Defence Infrastructure Organisation

Application Ref: EN010125

Our Reference: DIO10053433

Application by RWE Renewables UK Dogger Bank South (West) Limited and RWE Renewables UK Dogger Bank South (East) Limited for an Order Granting Development Consent for the Dogger Bank South Offshore Wind Farms.

Figure 15: Staxton Wold RLoS 379m amsl

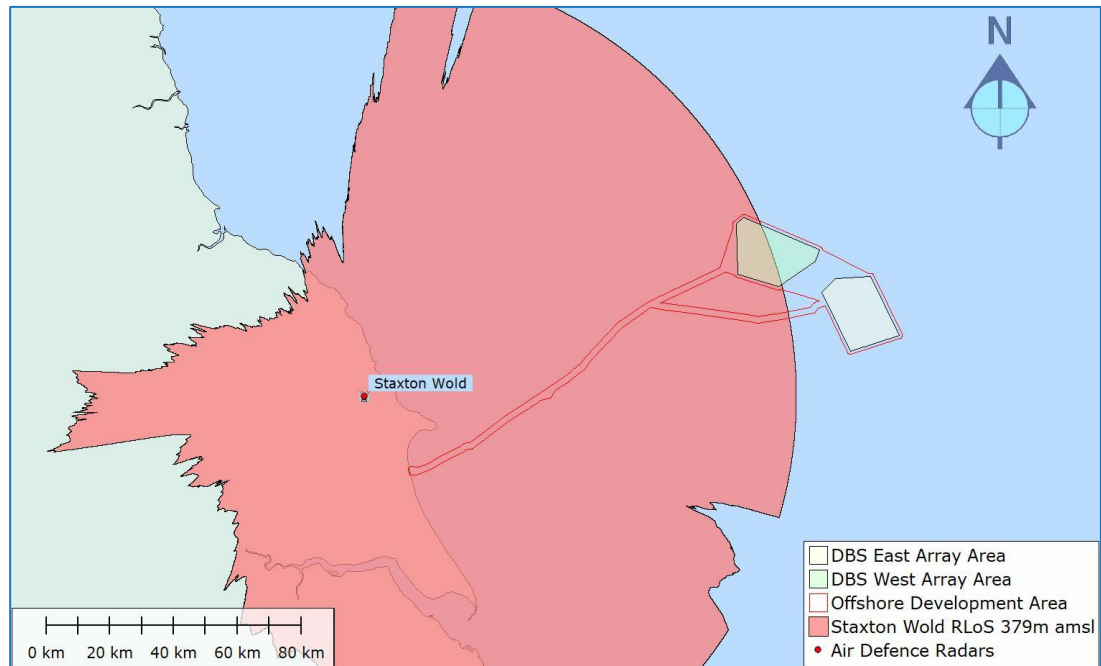
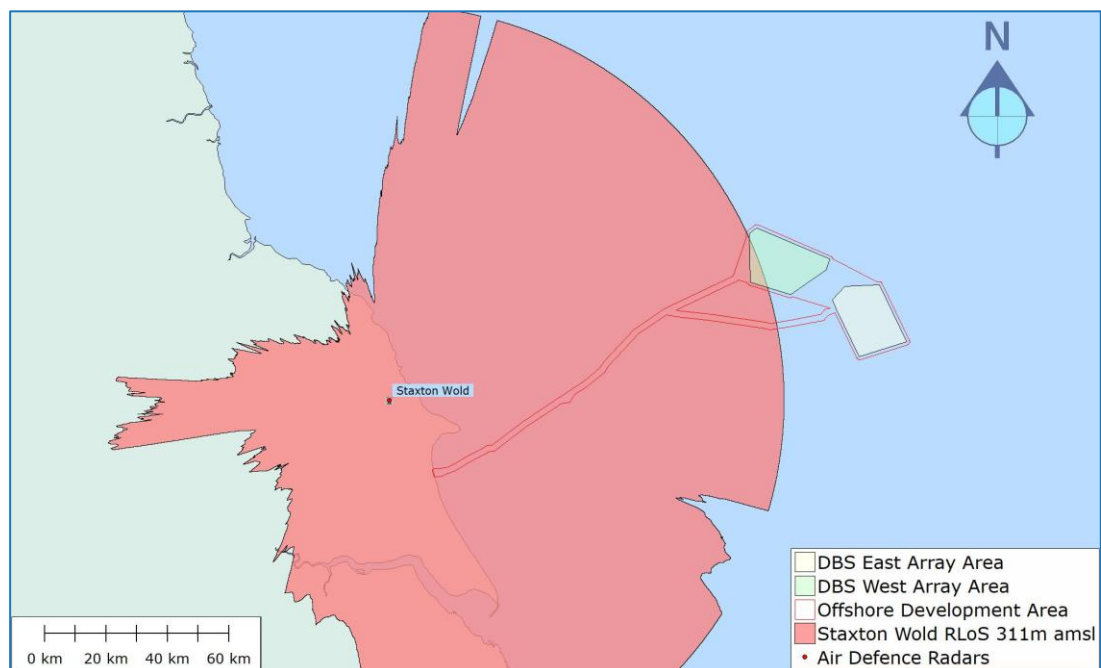
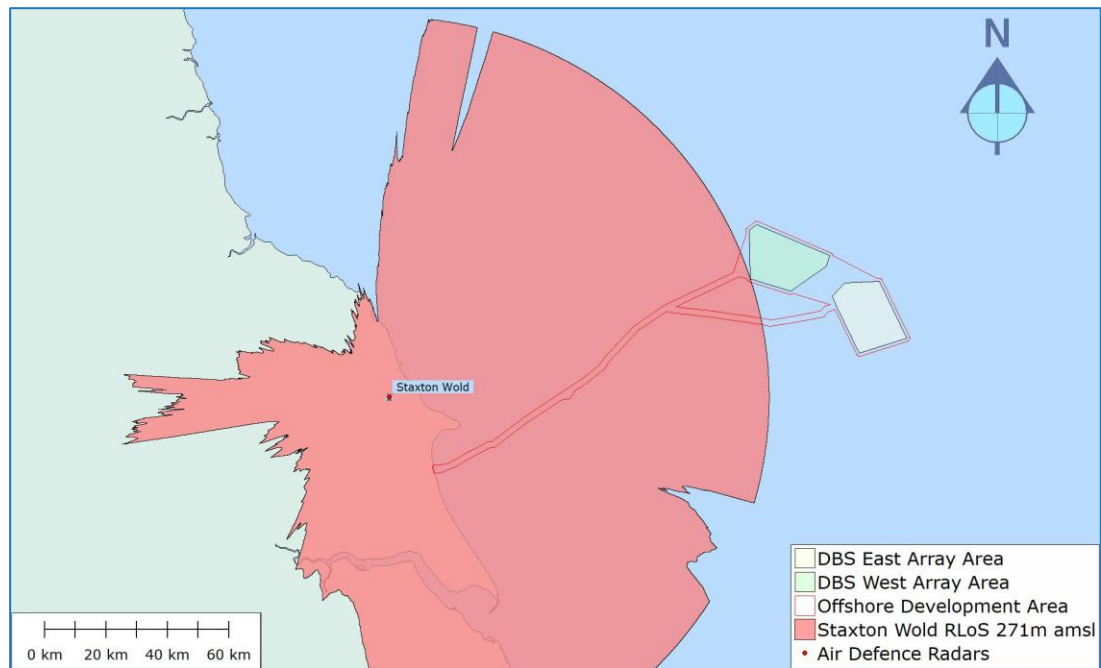
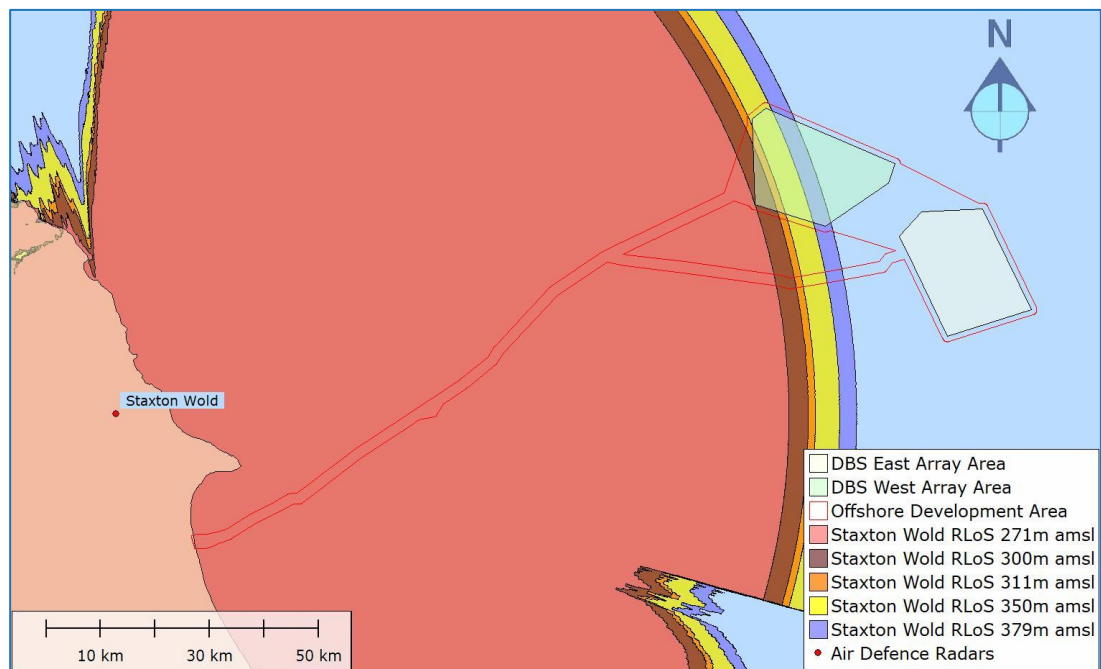
At this time the MOD must **object** to the proposed development on the basis that the scheme would have a significant and detrimental impact on the effective operation and capability of an Air Defence (AD) radar deployed at Remote Radar Head (RRH) Staxton Wold.

The proposed turbines would be located approximately 123.2km from, detectable by, and will cause unacceptable interference to, the AD radar at RRH Staxton Wold.

Wind turbines have been shown to have detrimental effects on the operation of radar. These include the desensitisation of radar in the vicinity of the turbines, and the creation of “false” aircraft returns. The probability of the radar detecting aircraft flying over or in the vicinity of the turbines would be reduced, hence turbine proliferation within a specific locality can result in unacceptable degradation of the radar’s operational integrity. This would reduce the RAF’s ability to detect and deter aircraft in United Kingdom sovereign airspace, thereby preventing it from effectively performing its primary function of Air Defence of the United Kingdom.

Our assessments have determined that, when operational, the proposed wind farm will cause unacceptable and unmanageable interference to the effective operation of the air defence radar deployed at RRH Staxton Wold.

Therefore, on the basis of the information provided, and until a suitable mitigation scheme has been submitted, assessed, and accepted, the MOD must **object** to this proposal due to the impact it will have on the AD radar at RRH Staxton Wold.

The applicant’s response to Relevant Representations (RRs) in PDA-013 (dated October 2024 revision 01) acknowledges the AD radar objection and have confirmed mitigation is required. The MOD welcomes engagement on this matter. It is the applicant’s responsibility to provide a technical mitigation solution to the MOD. Unless, and until, a mitigation is submitted and accepted by the MOD, the MOD is unable to remove the objection or agree to a Requirement to address this issue.
